From: Dawn Appleton [REDACTED]
Sent: 05 June 2018 16:09
To: Anita Gardner
Subject: RE: Planning Application EP/7/18

Subject: FW: Planning Application EP/7/18

Proposed Site Plan, Block Plan
and Location Plan

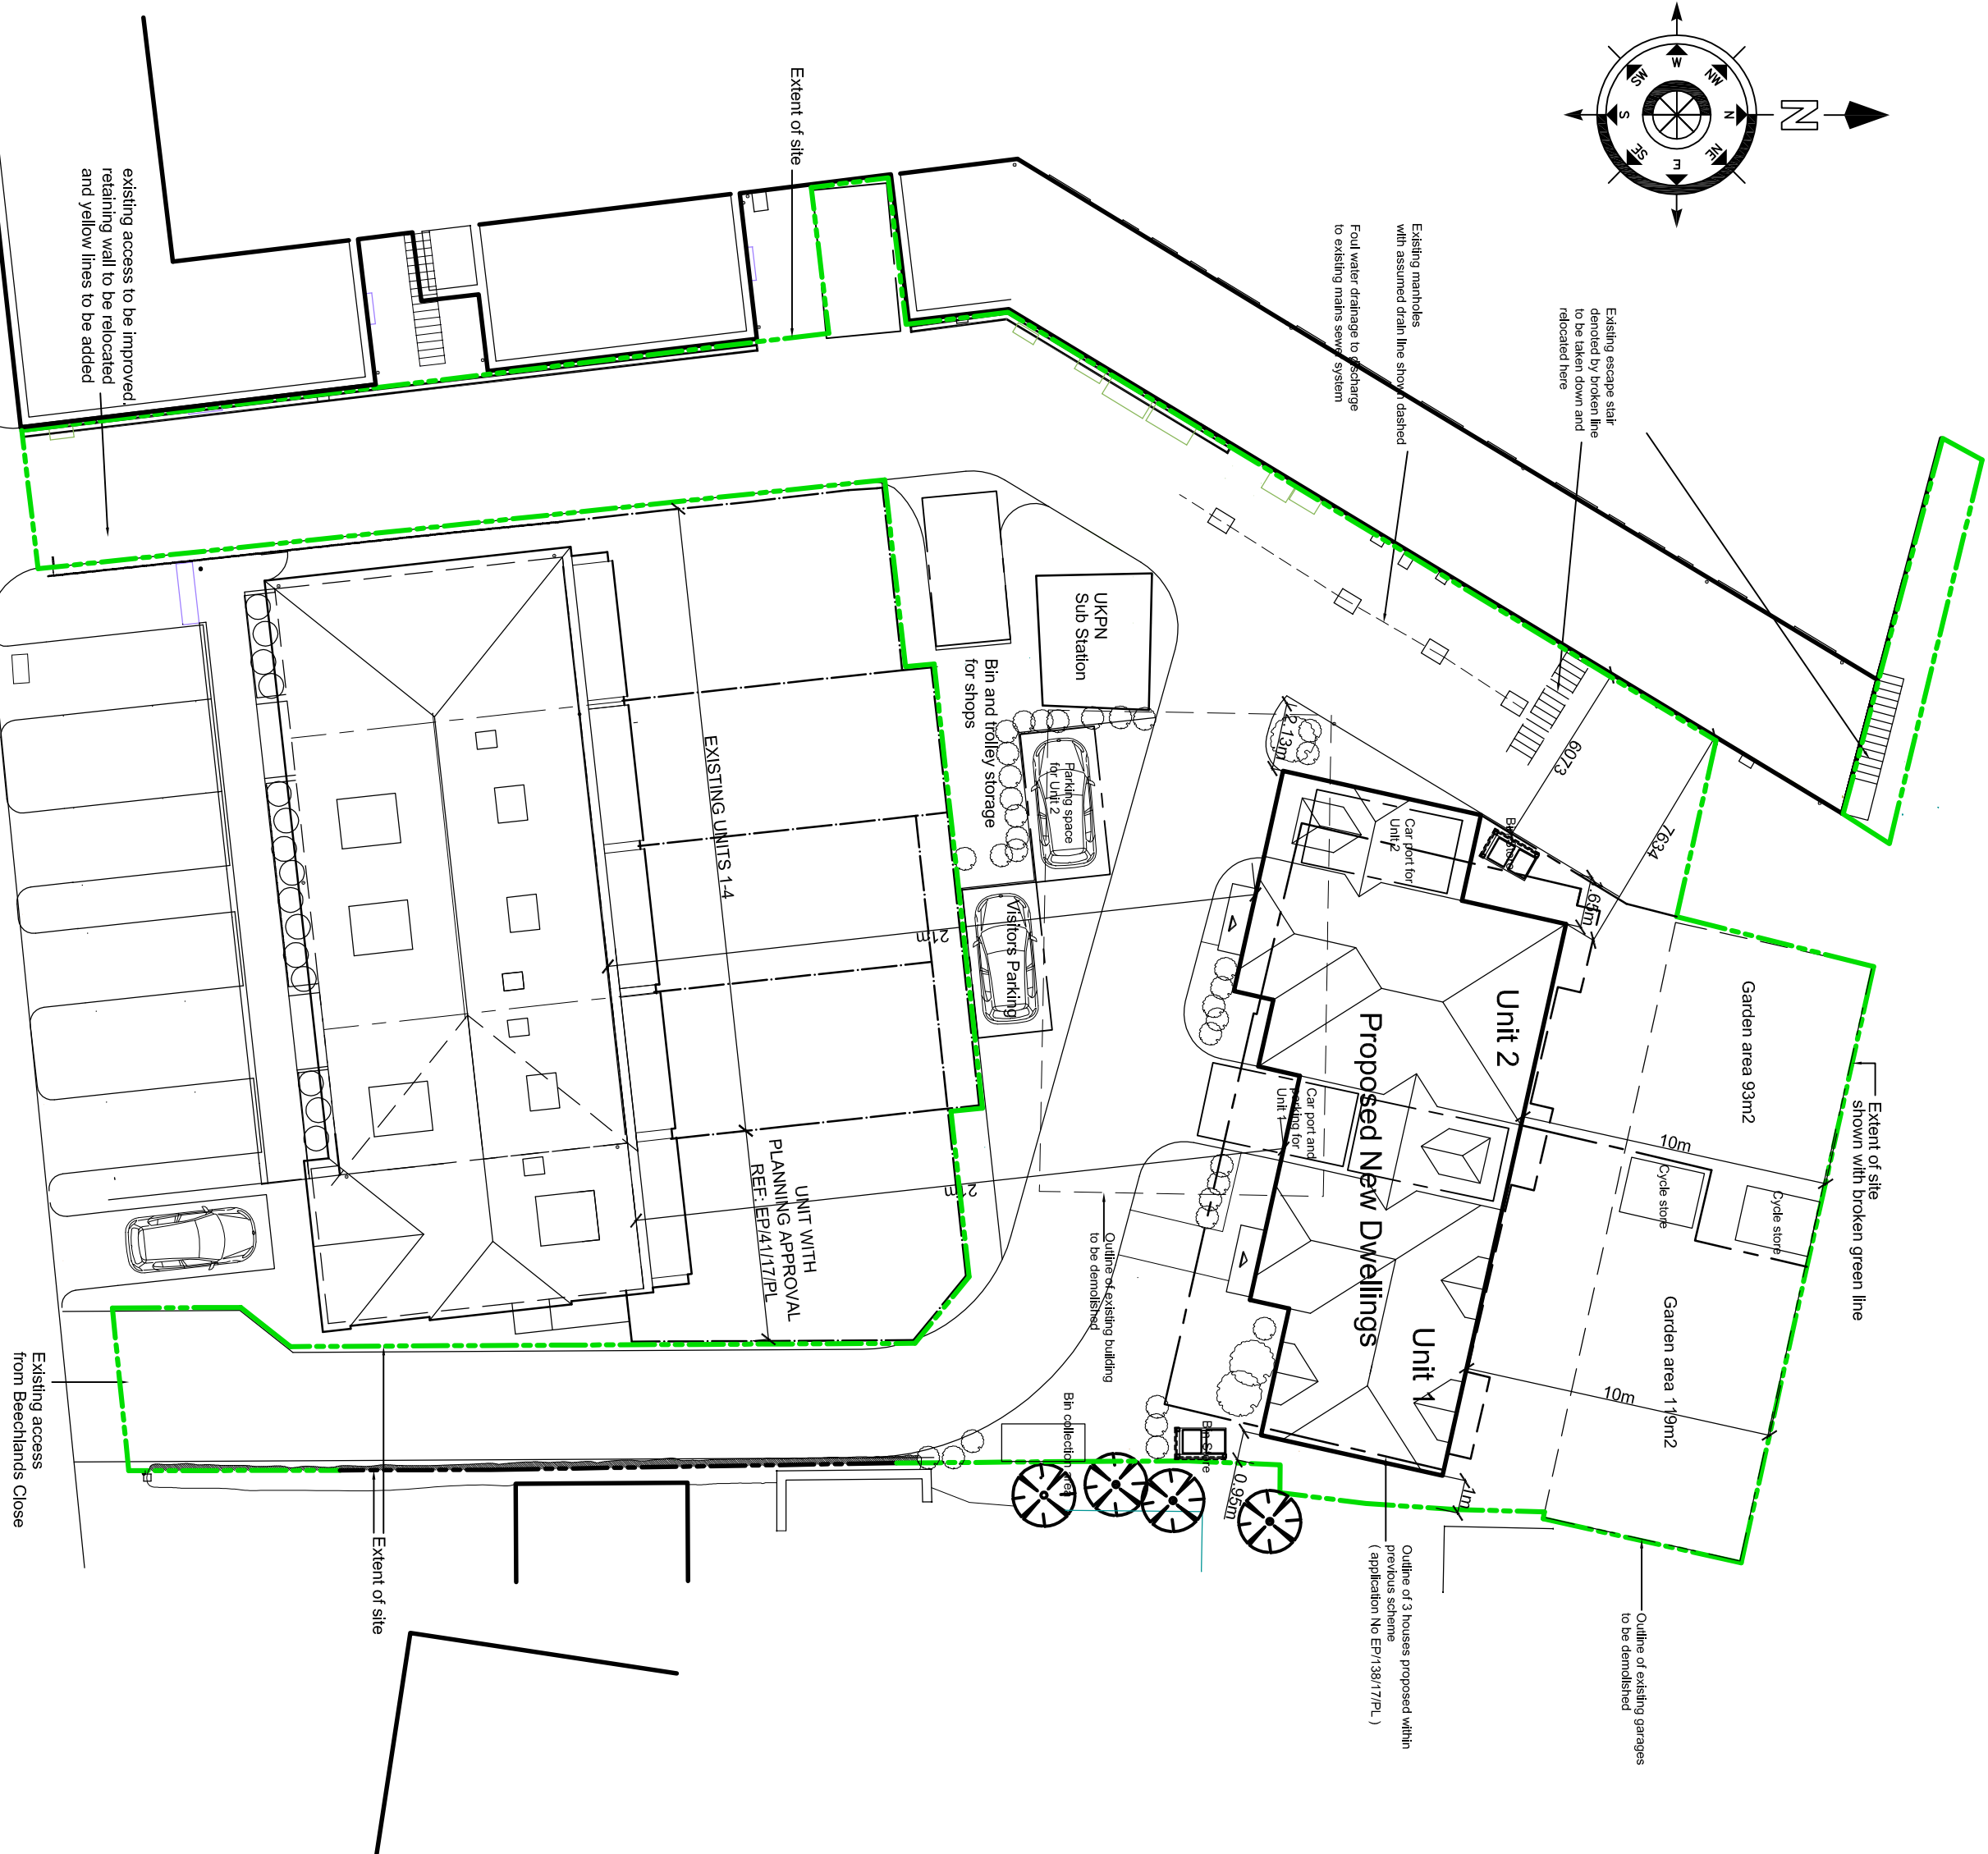
I have been reading the latest letter from Appleton Town Planners on your website and I note that we will be allocated 3 parking spaces within this latest application.

Do you think it would be possible to indicate where our proposed parking will be on the plan ?

Also for the UK Power Networks " ***to pass and repass at all times with plant and personnel for all purposes over and along the land coloured blue and brown on the said plan***" this refers to the ***proposed*** reduced access route on the

Eastern side of the development where we also have specific rights. I have a copies of the documents if you wish to see them. Parking will presumably be required for any operatives working on the sub-station along with their plant ,so again could I ask where this is shown on the plan ?

Any large delivery vehicles attempting to manoeuvre into this "improved access" would require to ride over the kerbs and pavements (as "One Stop" are allowed to do) due to the restrictions coming in from, and then presumably reversing back into Beechlands Close (blind) ..or is there a turning area ?
